**Your Ref:** OWPC23966  
**Our Ref:** EP/84/19/HH 03-07-2019  
**Please ask for:**  
Zac Denton

Two storey front extension (North), two storey side extension (West) and single storey rear extension (South). Alterations to external appearance, roof terrace over existing flat roof, roof lantern in existing flat roof & Juliette balcony to front of property.

10 Angmering Lane East Preston

Thank you for your internet representation made on 7th August 2019 which has been recorded as '**an objection**' with the comments as follows:

Drawing Title:
Proposed Plans, Elevations and Roof Plan

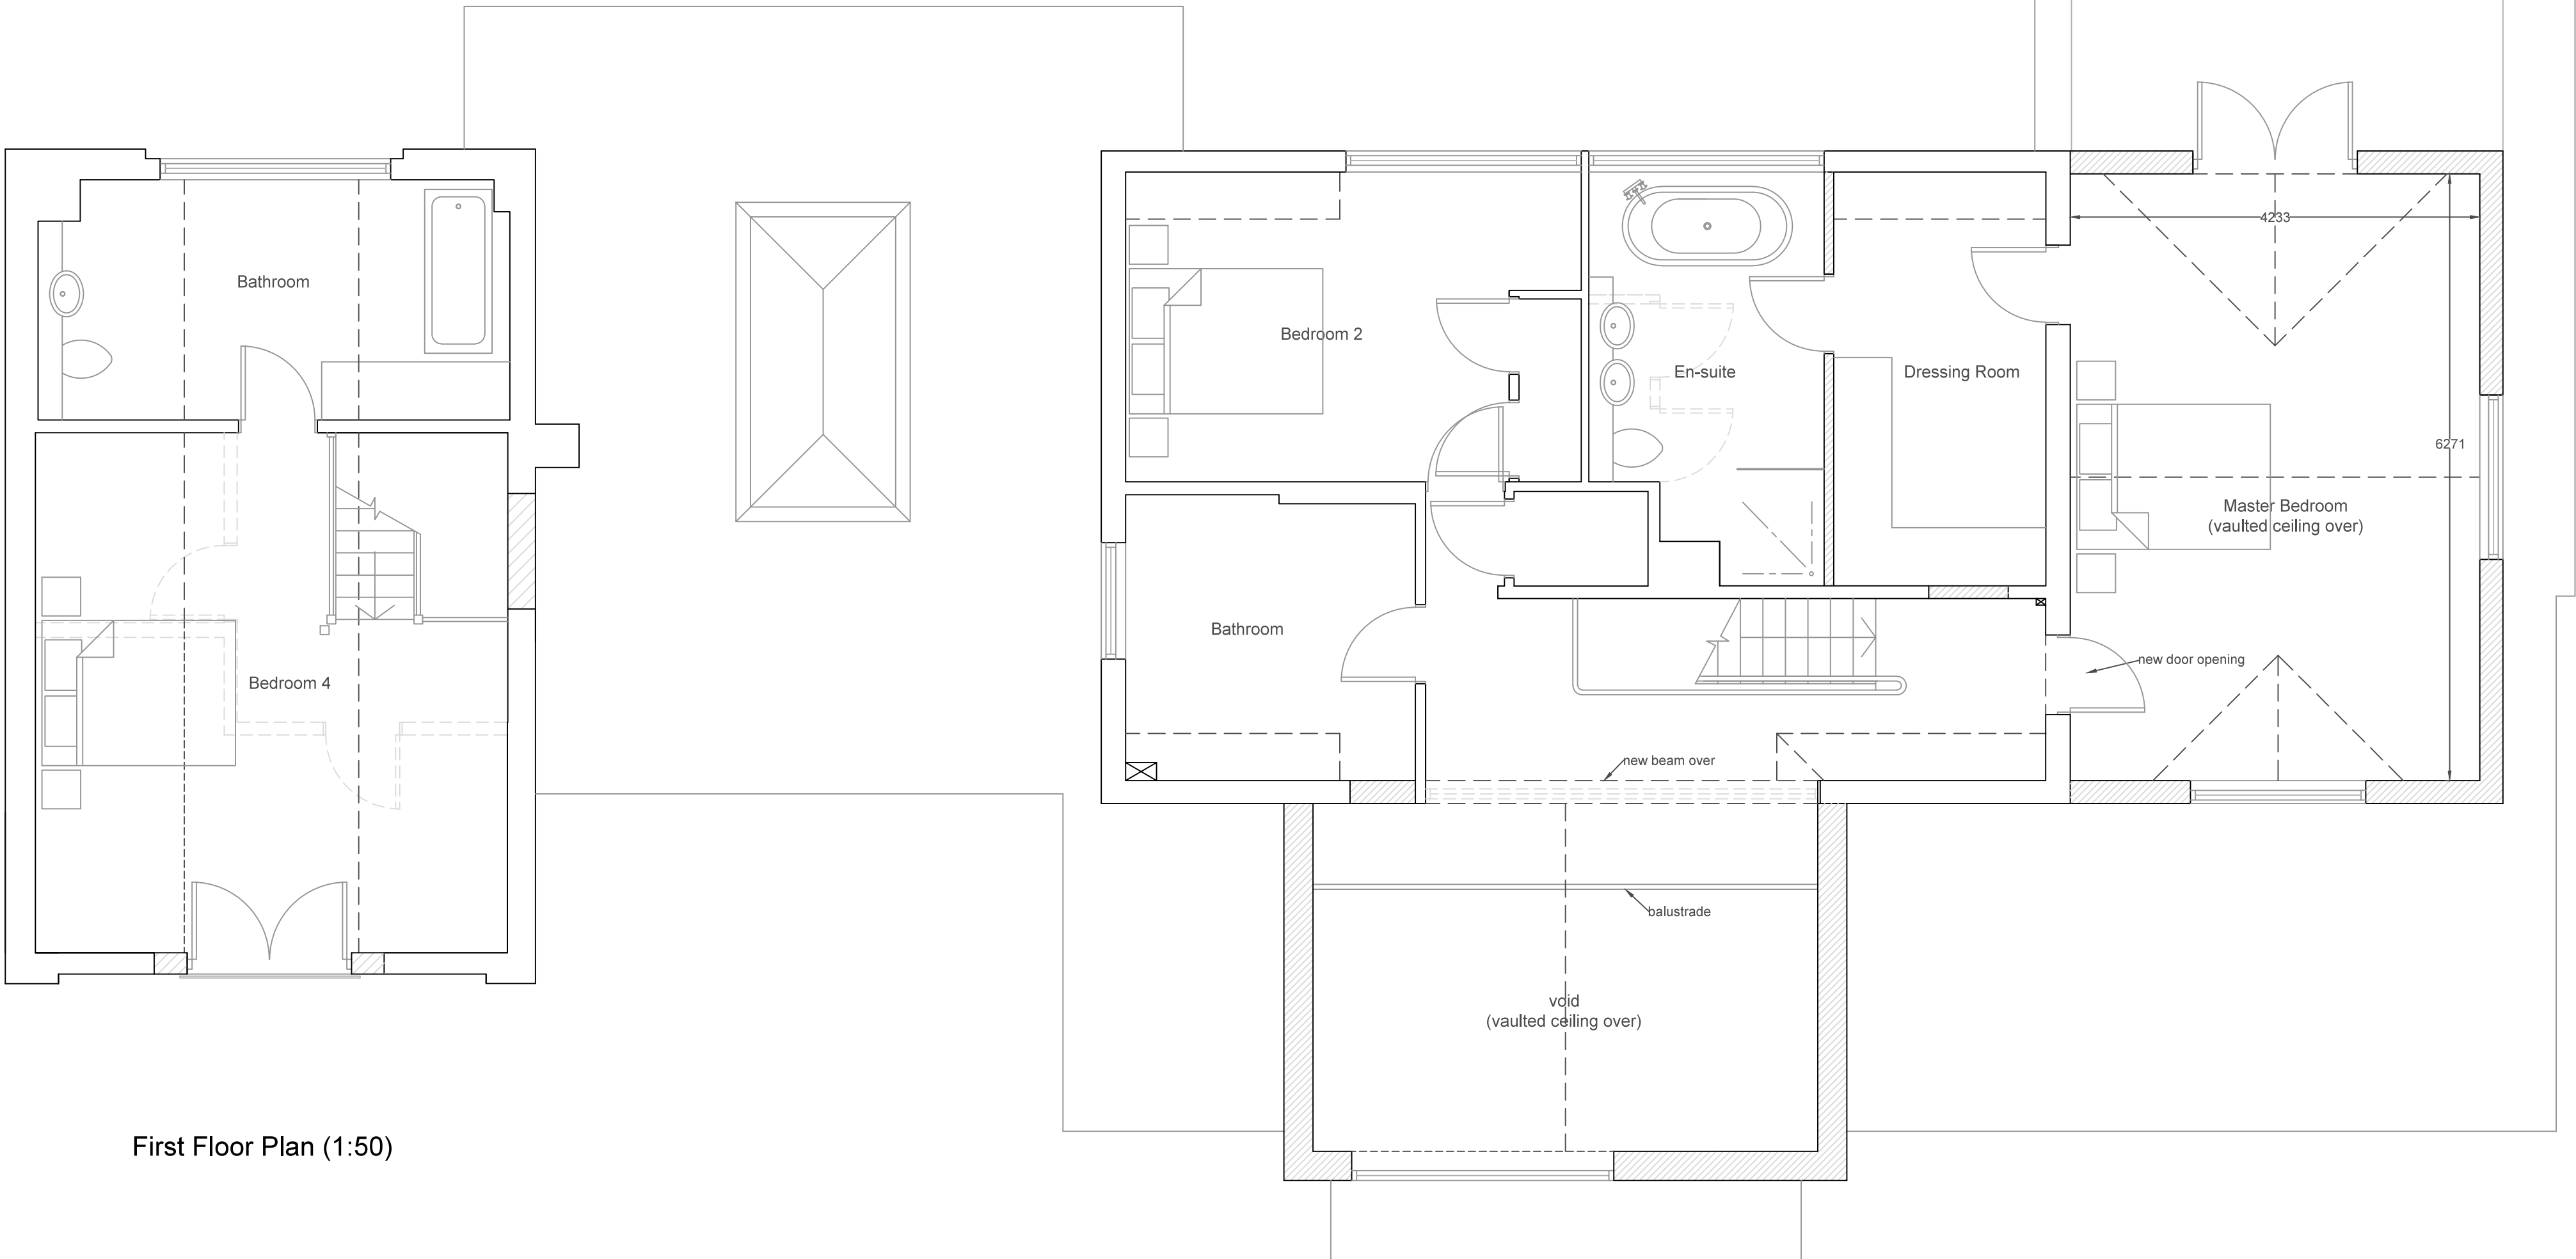
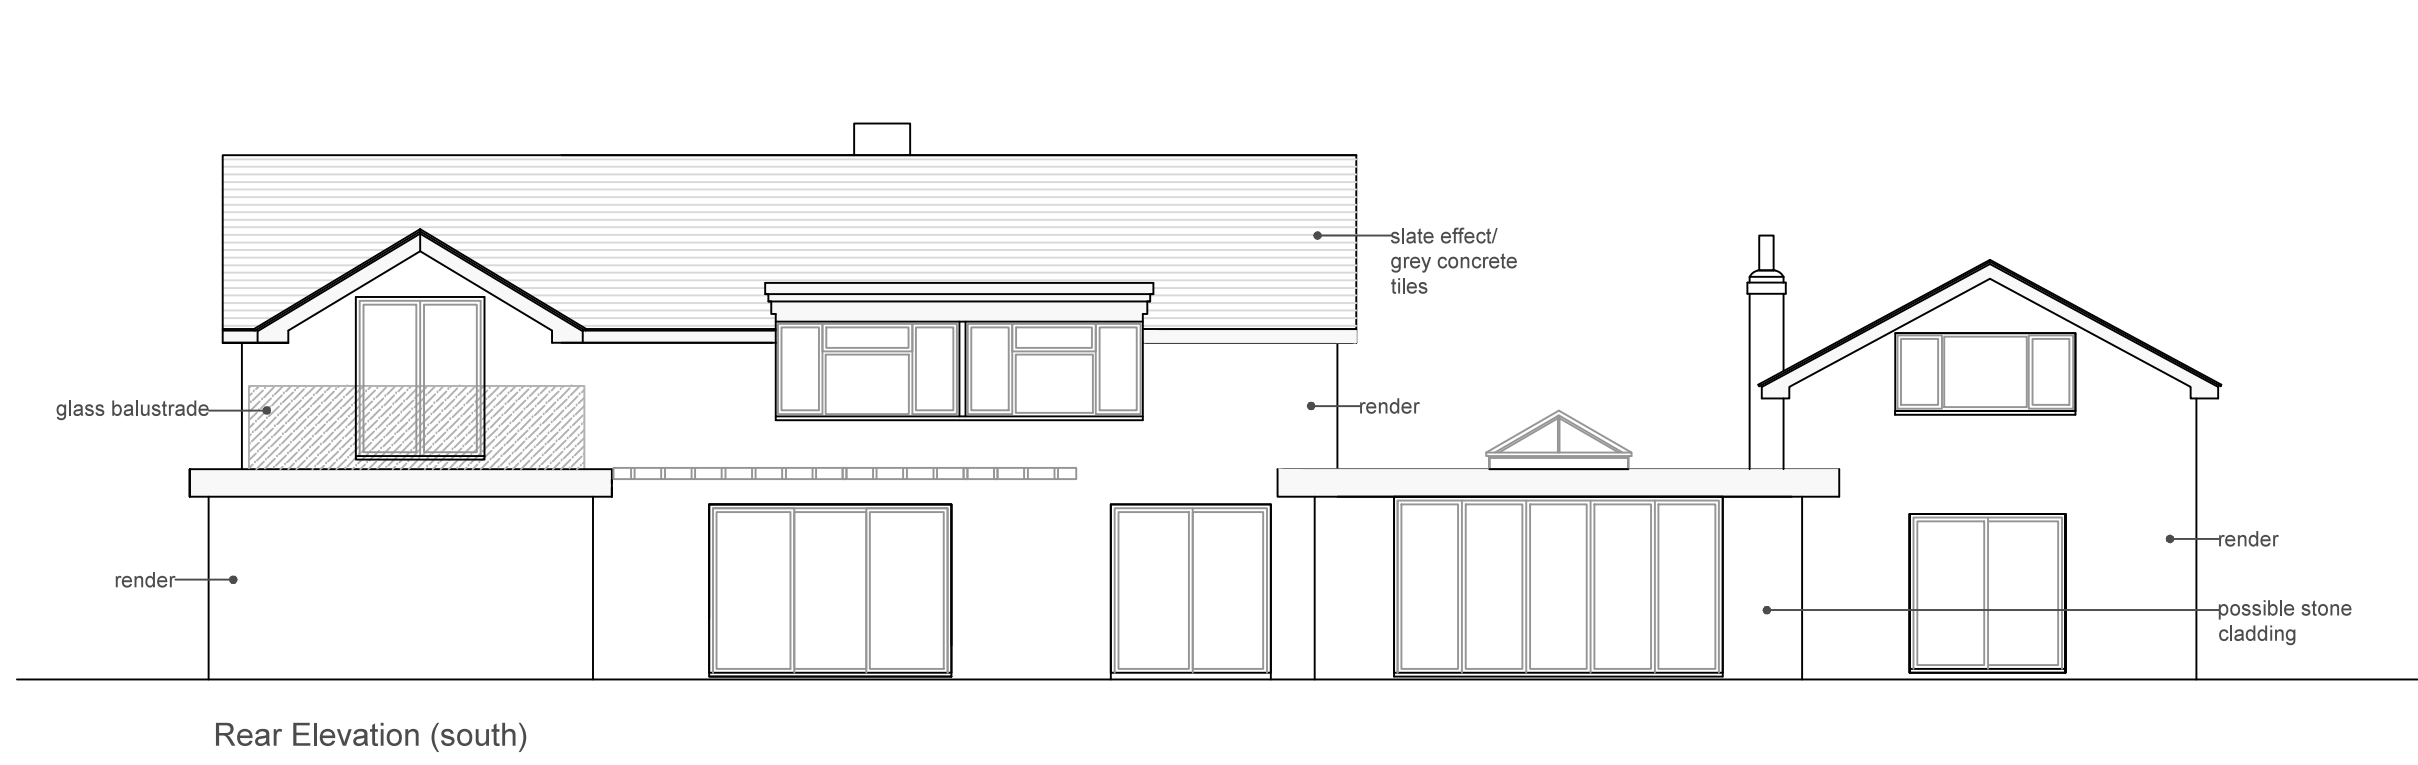
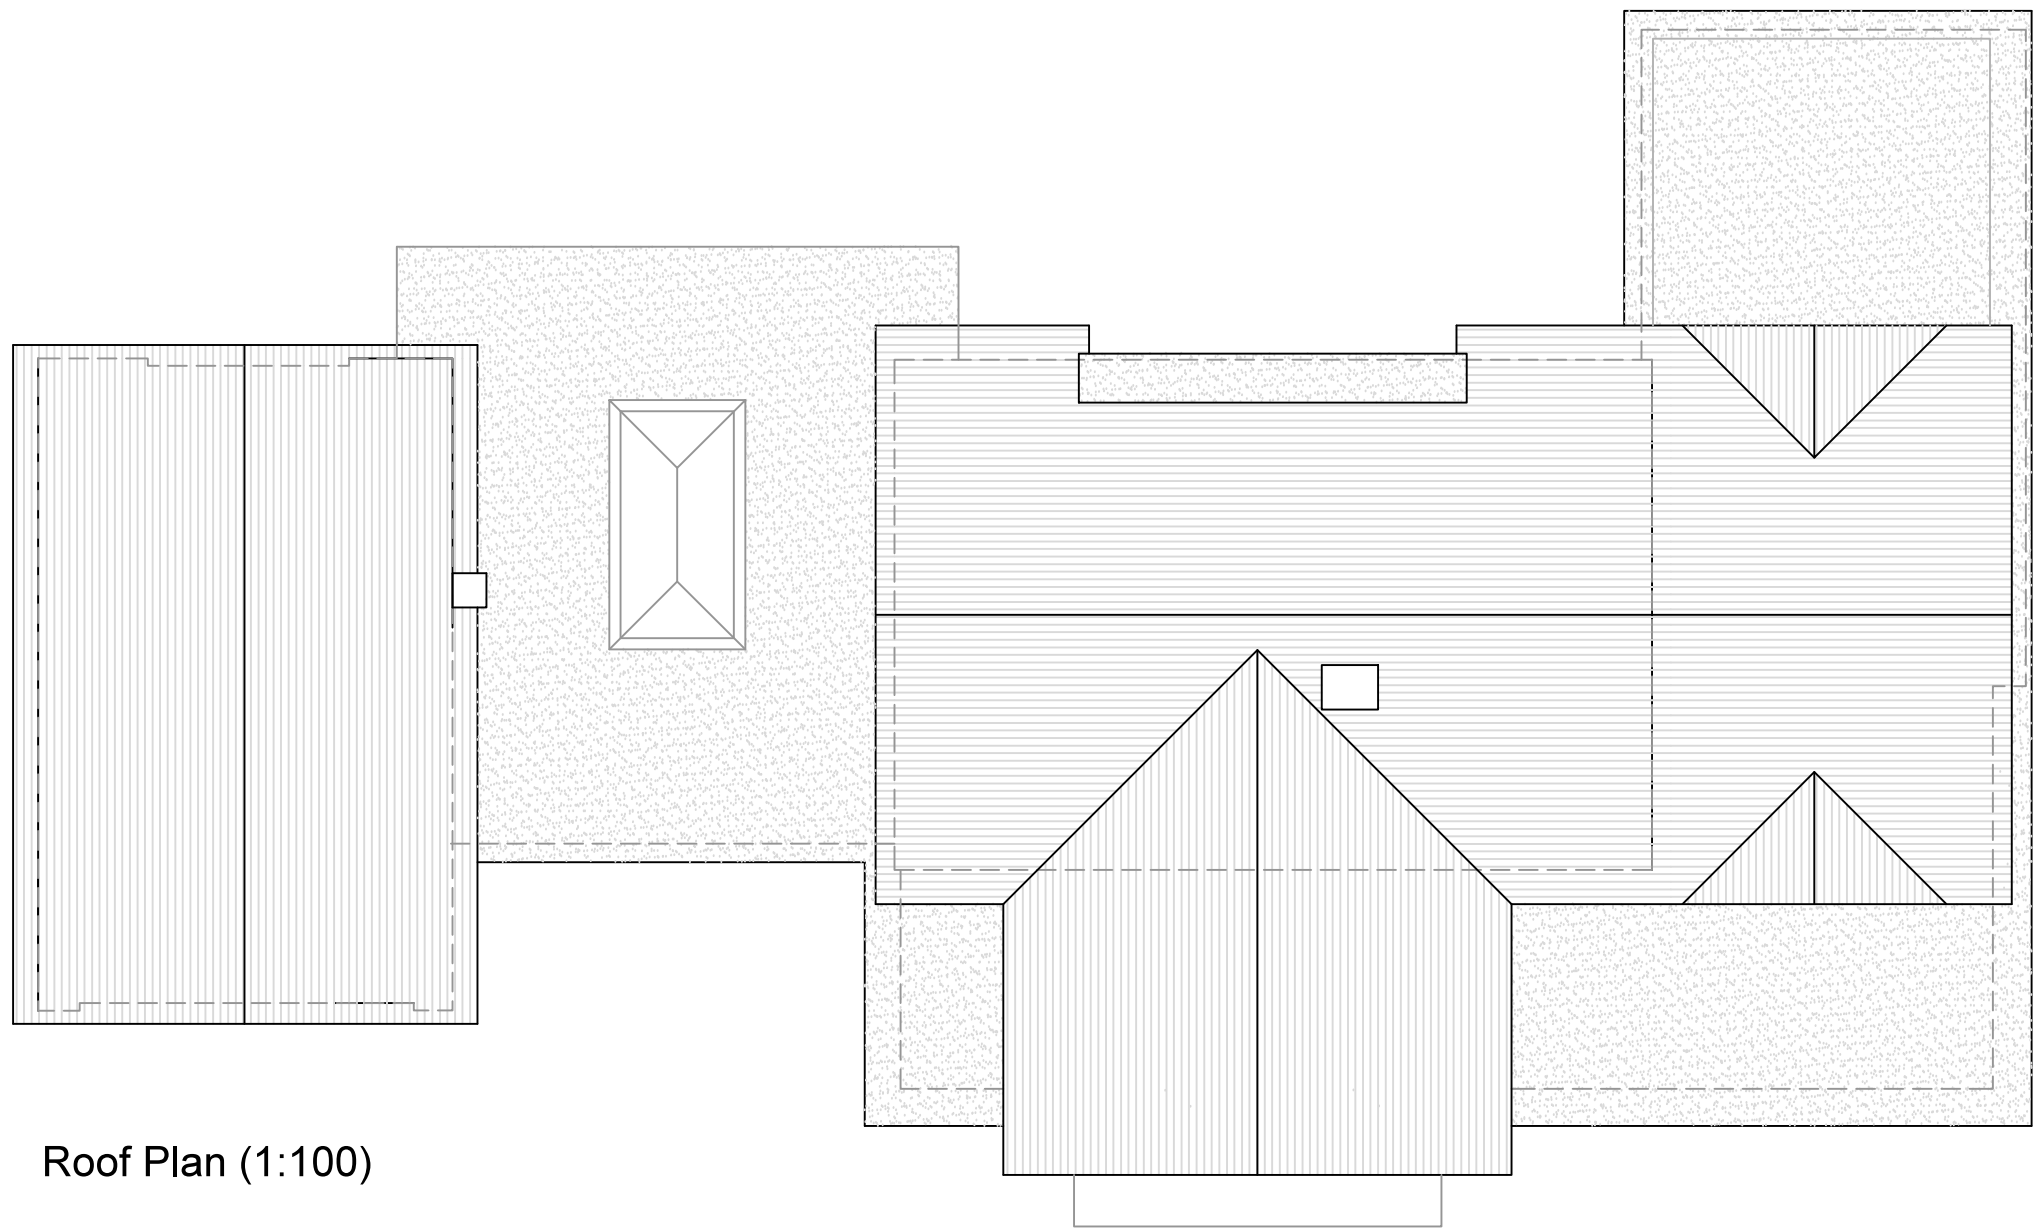
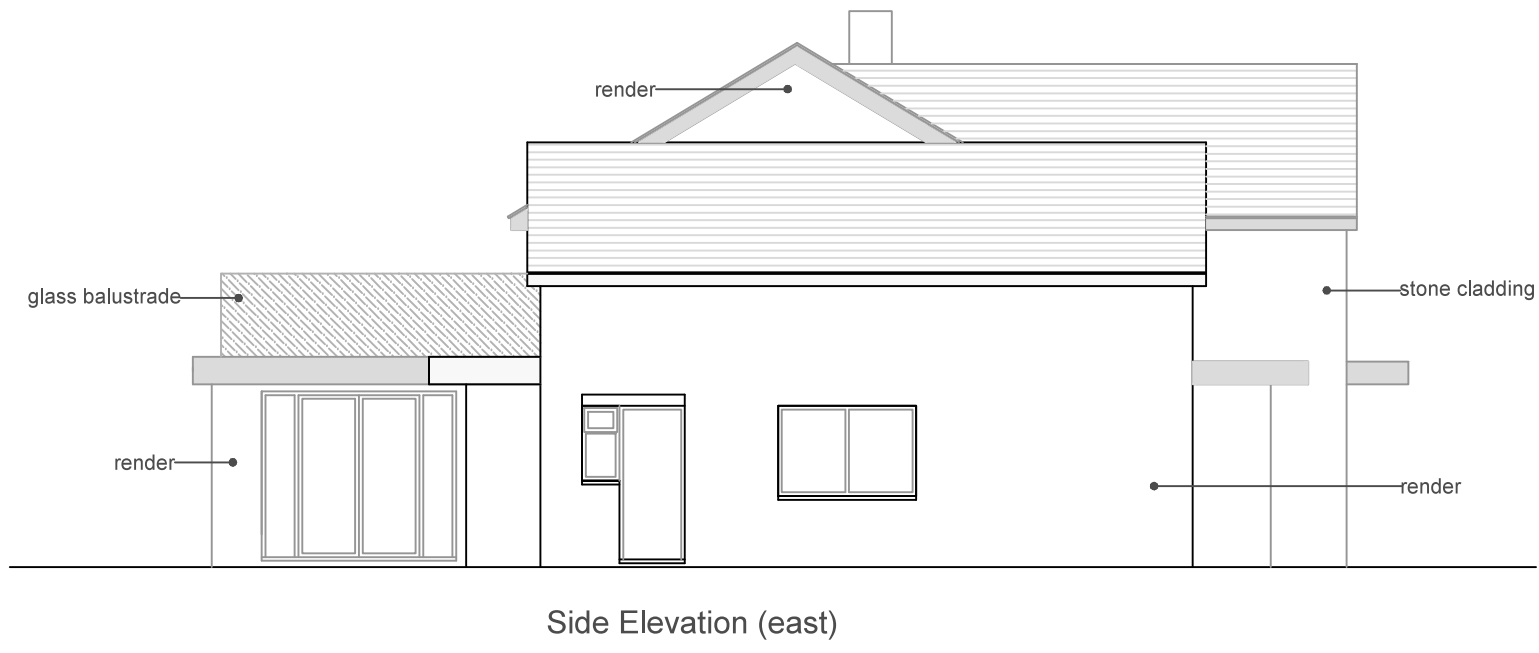
*The design of this house is characterised by the use of grey roofing tiles and windows, and extensive use of white plastic on other features of the facade. The result would be a house that did not reflect the character of the surrounding area in terms of the colour and texture of the materials used. The house would therefore contravene Policy D DM (1) of the Arun Local Plan.*
